Subject: RE: Attached letter from Kirklees Council regarding application number 2025/93435 at location Land off, Blackmoorfoot Road and Felks Stile Road, Crosland Moor, Huddersfield, HD4 7AD

Further to a review of the additional information provided, I would like to advise the following:

Title: **Highway Tank sections**

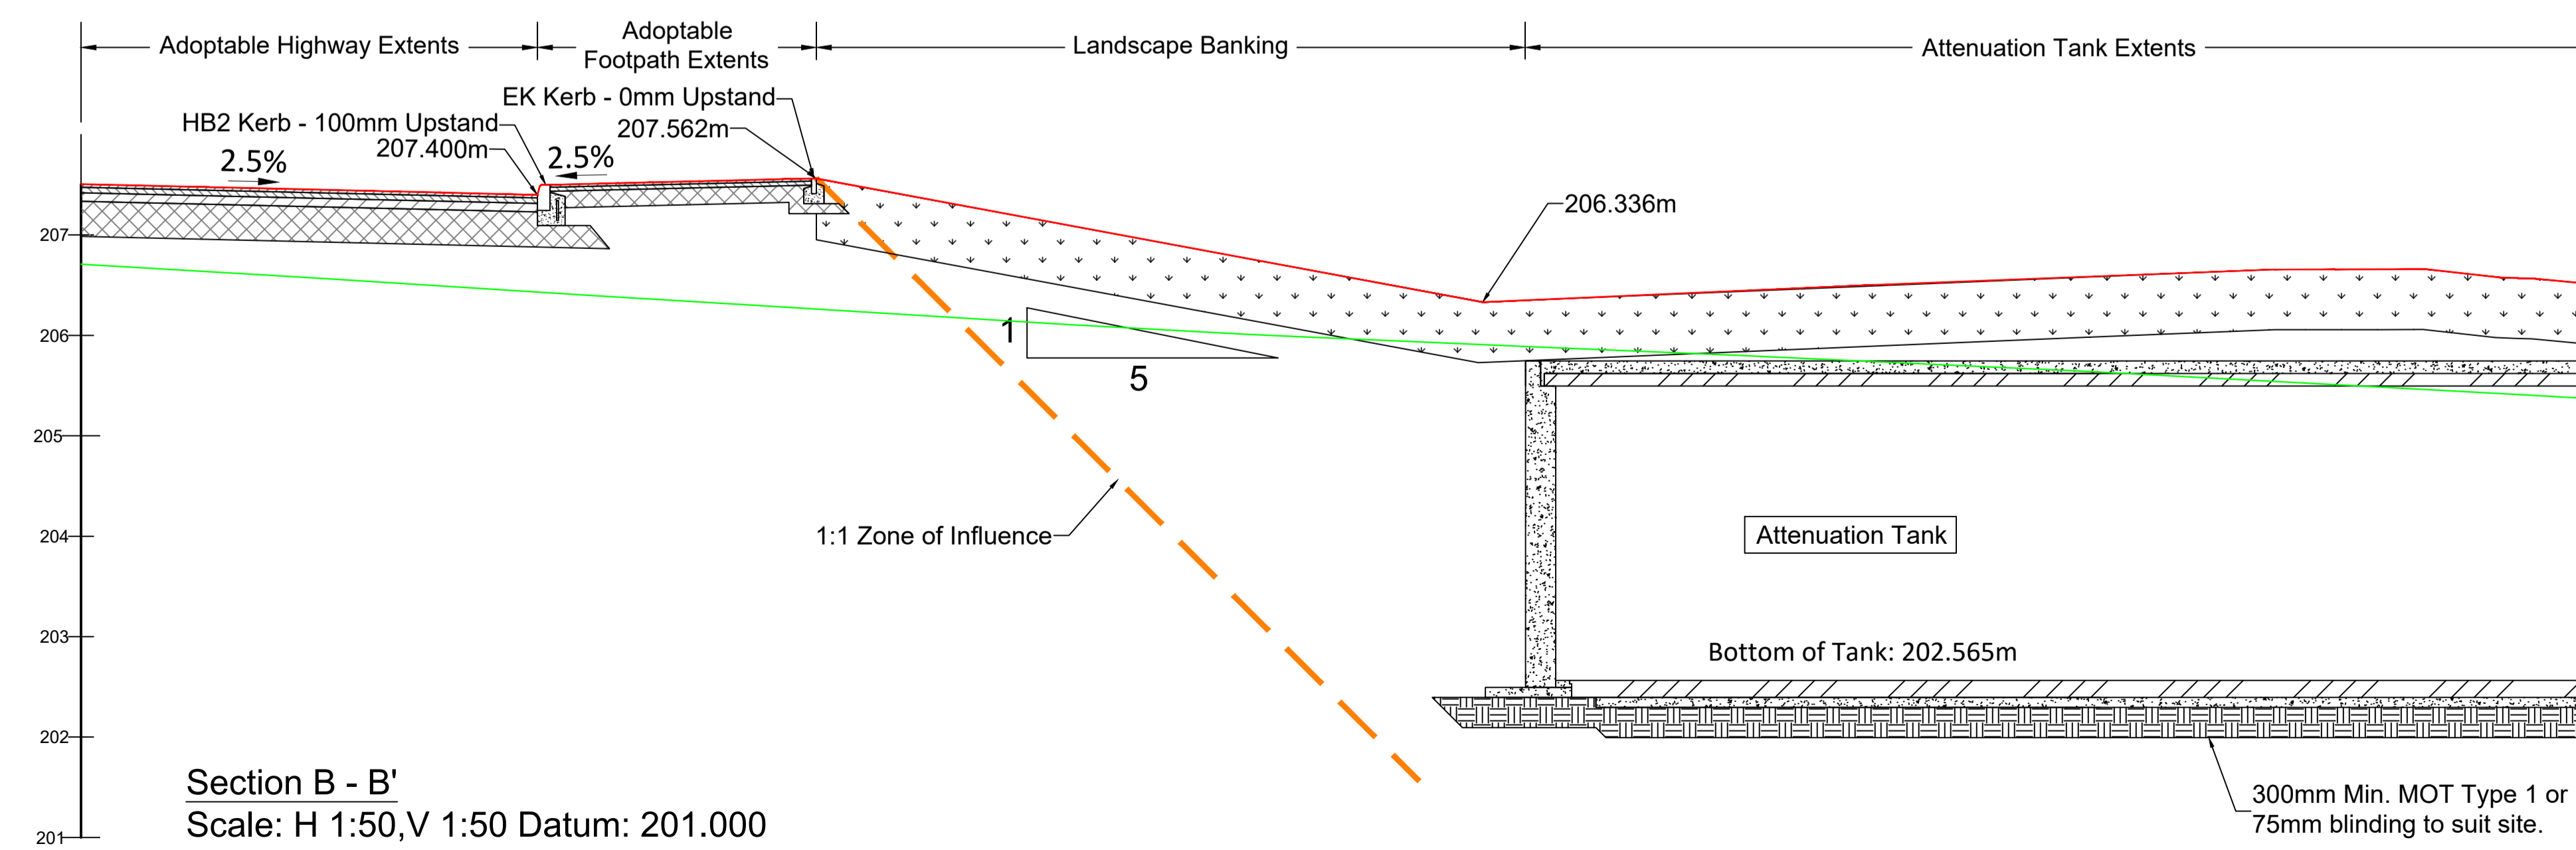
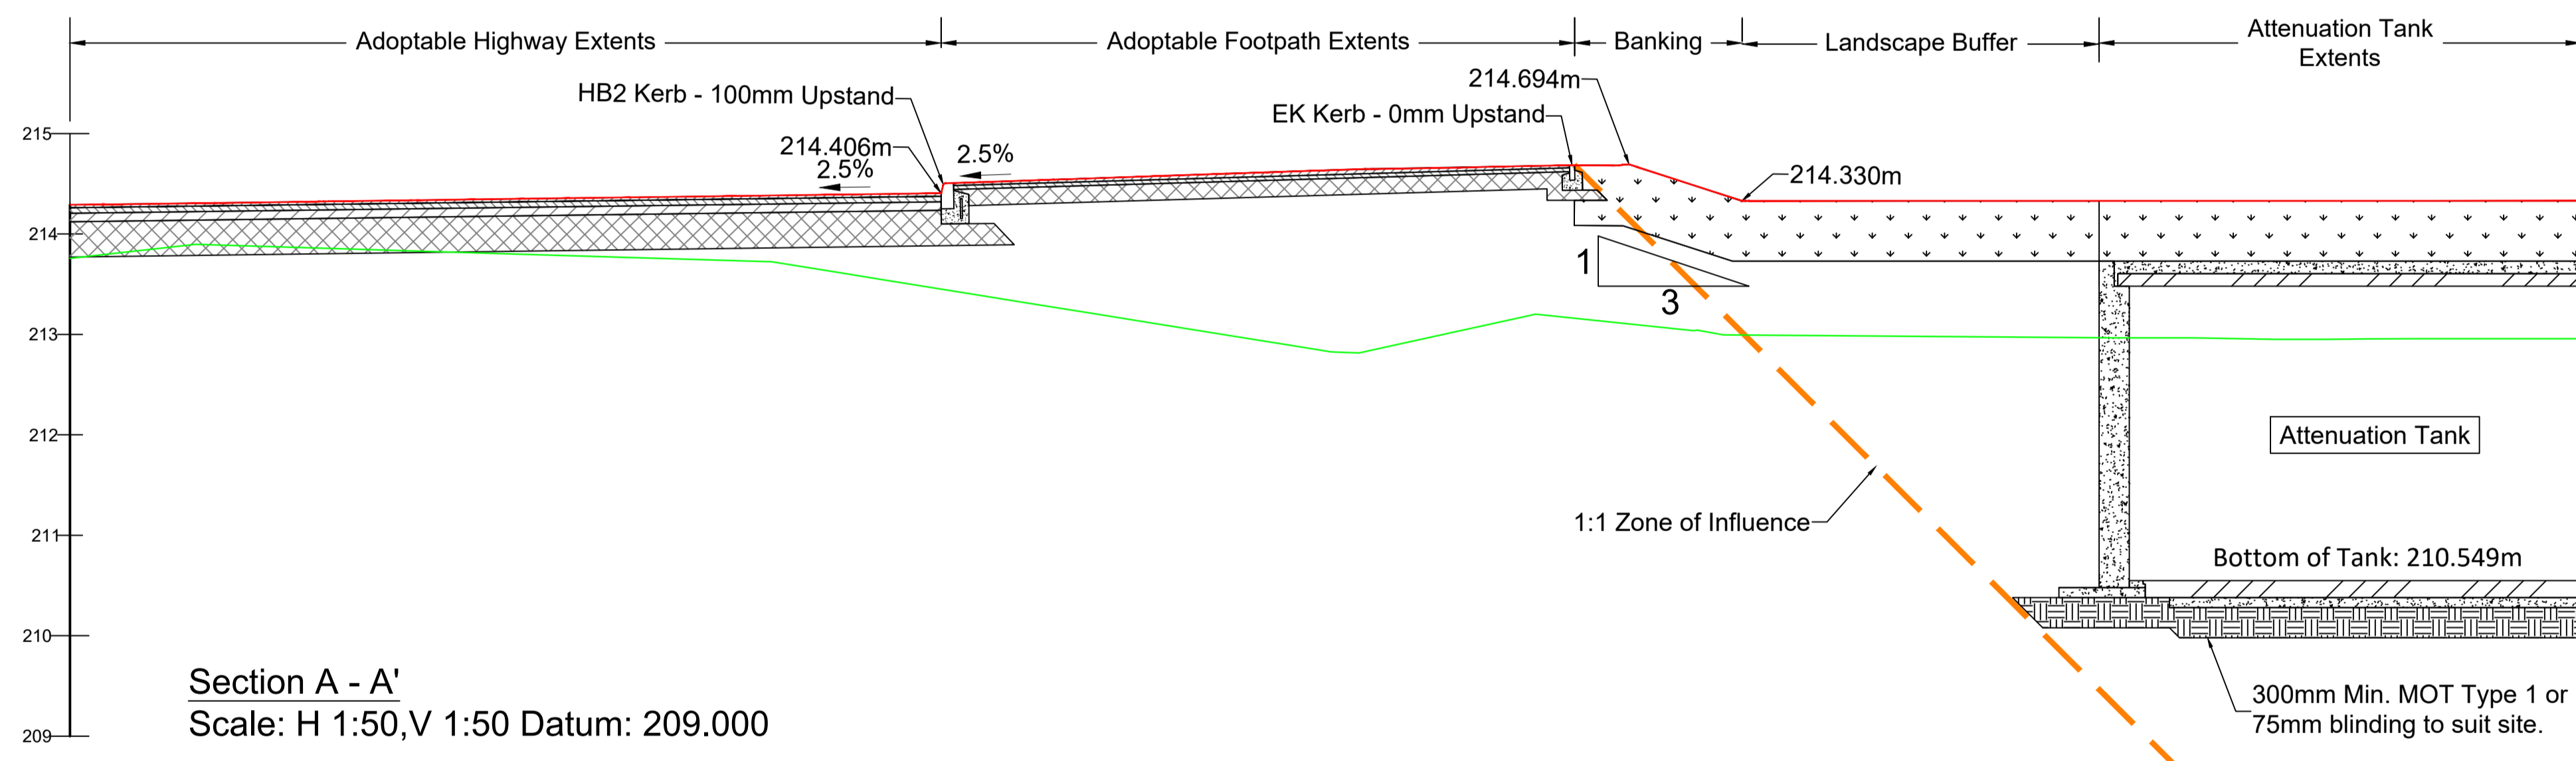
Condition 17 (surface water attenuation in highway)- This condition can not be discharged pending the submission of a manhole schedule for the proposed surface water drainage system installed in the highway. In addition, it should be noted that this comment is based on drainage drawings produced by ADEPT and not ARP drawings which are understood to have been superseded and as such should be moved elsewhere.
